RE: **APS Montgomery Complex**
3315 Louisiana Blvd NE
Drainage Report and Grading Plan
Engineer's Stamp Date: 4/25/17
Hydrology File: G18D048

Based on the information provided in your submittal received 4/26/17, and updated information received on 5/1/17, the Drainage Report and Grading Plan are approved for Grading and Building Permit.

RE: APS Montgomery Complex; G18D048

Dear Mr. Peterson,
Wilson & Company has reviewed the comments provided in an email dated April 25, 2017 on the APS Montgomery Complex Project. **Below are the responses to the comments:**

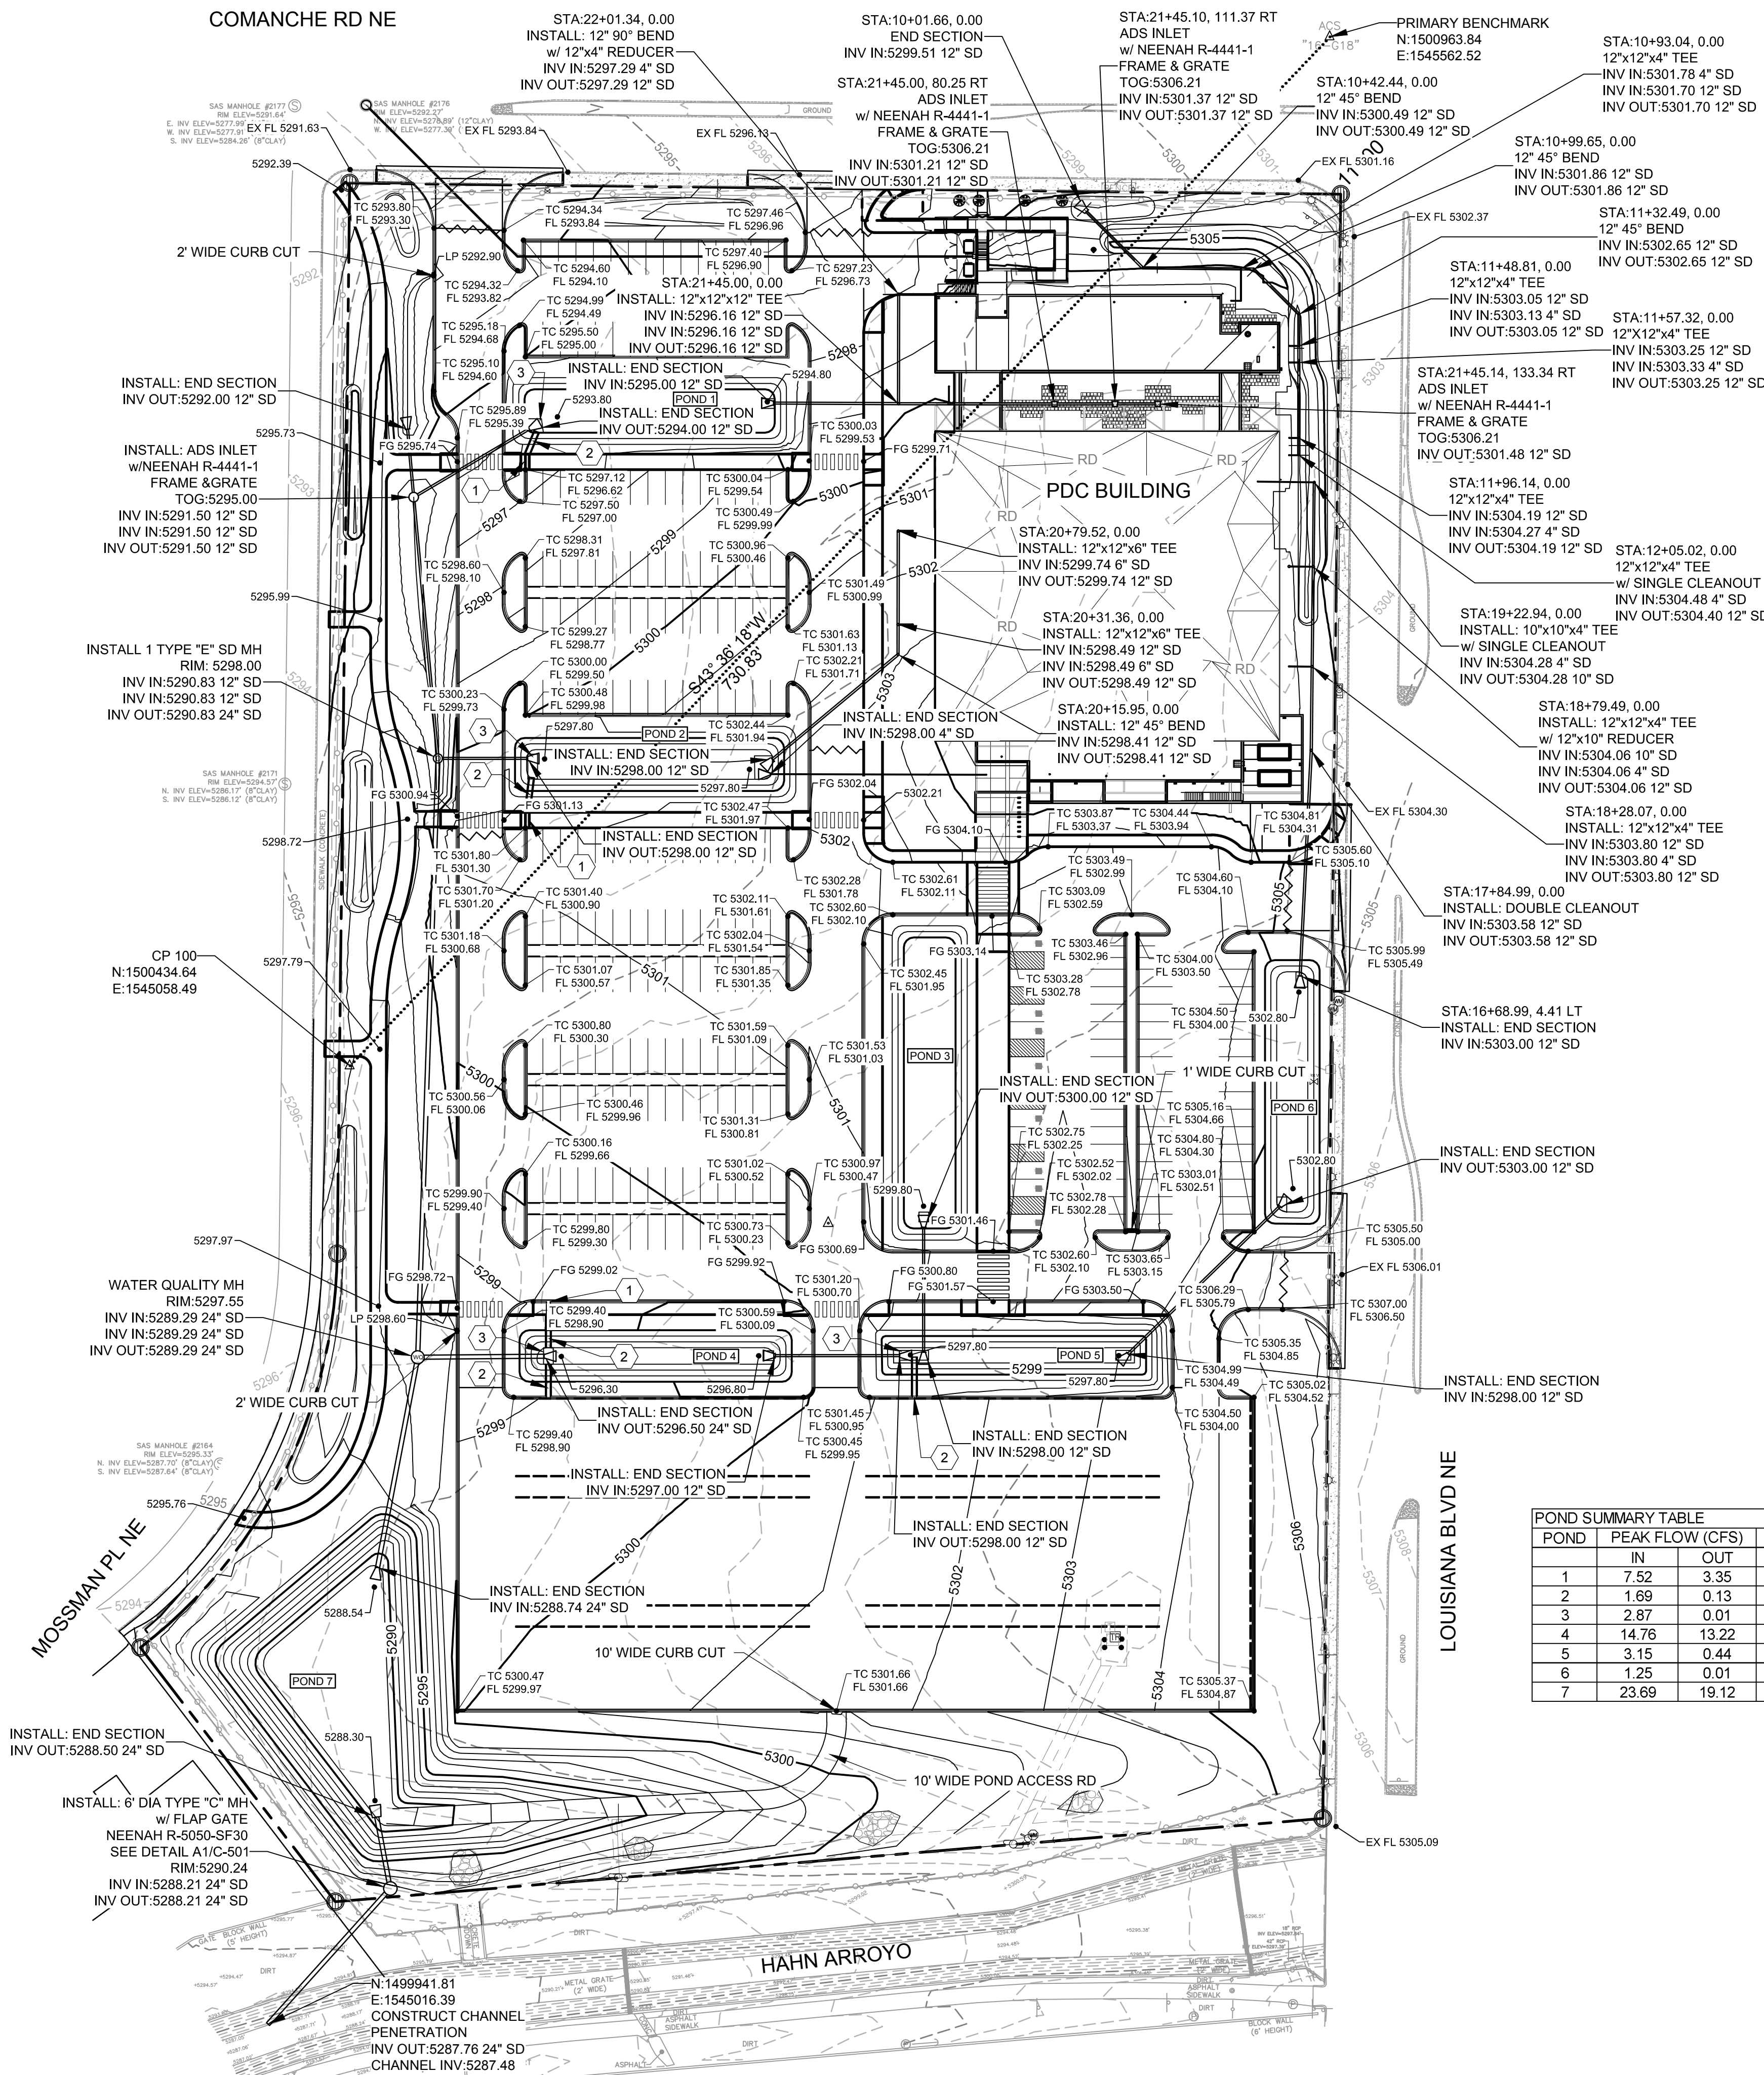
1. Provide finished floor elevation for the PDC building. Assuming the PDC building footprint is outside the Zone AO on Comanche, state so in the report (section 1.3). **Note added to Overall Grading & Drainage Plan and report.**

7. The penetration into South Hahn may be performed under S0-19 or mini- work order. State how the work will be performed on the Grading Plan. If using S0-19, include standard S0-19 notes. Prior to beginning work, notify Jason Rodriguez with Municipal Development to coordinate an inspection schedule (jtrodriguez@cabq.gov). **Penetration will be performed under work order 772071. Note added on Overall Grading & Drainage Plan.**
